### Sydney Metro State Significant Development, Development Application (SSD DA) Pitt Street North Over Station Development

Appendix E - SSD DA Response to Submission Transport and Traffic Accessibility Impact Letter

### Re: SSD DA Response to Submission – Transport and Traffic Accessibility Impact Letter

**Figure 31 | Car stacker and Loading dock layout (Source: RtS)**

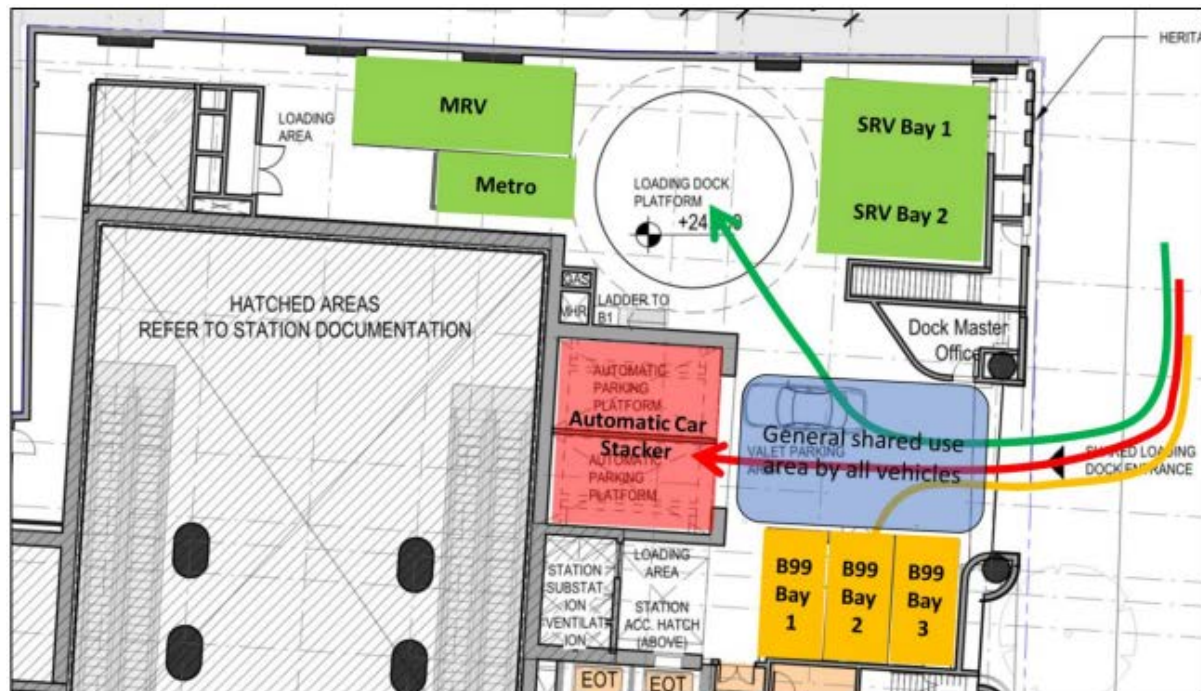
The vehicle access and queuing arrangements are unclear. Limited space is provided for vehicle waiting, queuing and manoeuvring.

Vehicular access arrangements must be redesigned to reduce the need for vehicles to queue on the street to enter the site or by moving loading and servicing vehicles on street, which would impact on the busy footpath, street, and bus lane. In addition, a cycleway along Castlereagh Street is planned adjacent to the site.

The design assumes all vehicles will travel in the same direction, at the same time, which will be difficult to manage. The proposed usage of the lifts, in AM for inbound flow and PM for outbound flow, would not be guaranteed, and is dependent on tenancy types. If vehicles are exiting the lift, the proposed waiting arrangement will not work (see Figure 1 below).

The waiting area for vehicles using the car lift and automatic stacker limits use of both loading areas. The transport report proposes that no loading and servicing access be available during peak time/s, however, it is not clear how access arrangements will be managed during other times or if a loading vehicle enters the site during this time.

As discussed above, the design of the access to the loading area, driveway, and waiting area for the lifts could potentially lead to conflicts between the vehicles accessing the car lifts, using the driveway, people leaving their vehicle (although this arrangement requires clarification) and the loading dock.

As shown in Figure 2-2, access to the commercial parking is via the automatic car lift. There are two dedicated automatic car lifts available for a total of 40 car parking bays stacked over three levels. The 40 bays will be utilised by commercial tenant and longer dwell time service delivery vehicles only, and no public parking has been allowed for at North OSD.

As shown in Figure 2-3, the area within the OSD North loading dock on approach to the automatic car lift is estimated to hold up to four B99 vehicles without impacting the Castlereagh Street public domain. It should be noted that this does not include the two vehicles already using the automatic car lift. As such, the automatic car lift is not estimated to have an impact on the adjacent corridor or access to the loading dock via Castlereagh Street including the pedestrian footpath.

A booking system will be used for managing the arrival and departures of the loading dock requirements. A typical loading dock booking activity profile is shown in Figure 2-4 (also provided in Landscape as Attachment 1) combining the use of the loading dock and the commercial tenant access to the automatic car stacker. A delivery exclusion period during the peak commercial tenant arrival (i.e. 7 – 9am) is proposed and there is contingency within the loading dock to accommodate the arrival and departure of loading vehicles. In the event that a vehicle arrives unexpectedly outside the scheduled booking timeframe to the loading dock, the vehicle can still be accommodated for within the loading dock. Further details are provided in Section 4.3 of the SMCSWSPS-AUR-OSN-TF-PLN-000001 Transport and Accessibility Impact Assessment submitted with the Detailed SSD DA (**SSD-10375**).

The North OSD provides a total of 7 on-site service vehicles bays including a Sydney Metro operational bay as shown in Figure 2-6. Within the loading zone there is a 'general share use area', highlighted blue, which will be used by all vehicles using the loading dock. This includes the commercial tenants who will access the automatic car stacker (highlighted in red), the B99 bays at the southern section of the loading dock for service deliveries (highlighted in orange), and larger vehicles and the Sydney Metro Bay in the northern section of the loading dock (highlighted in green).
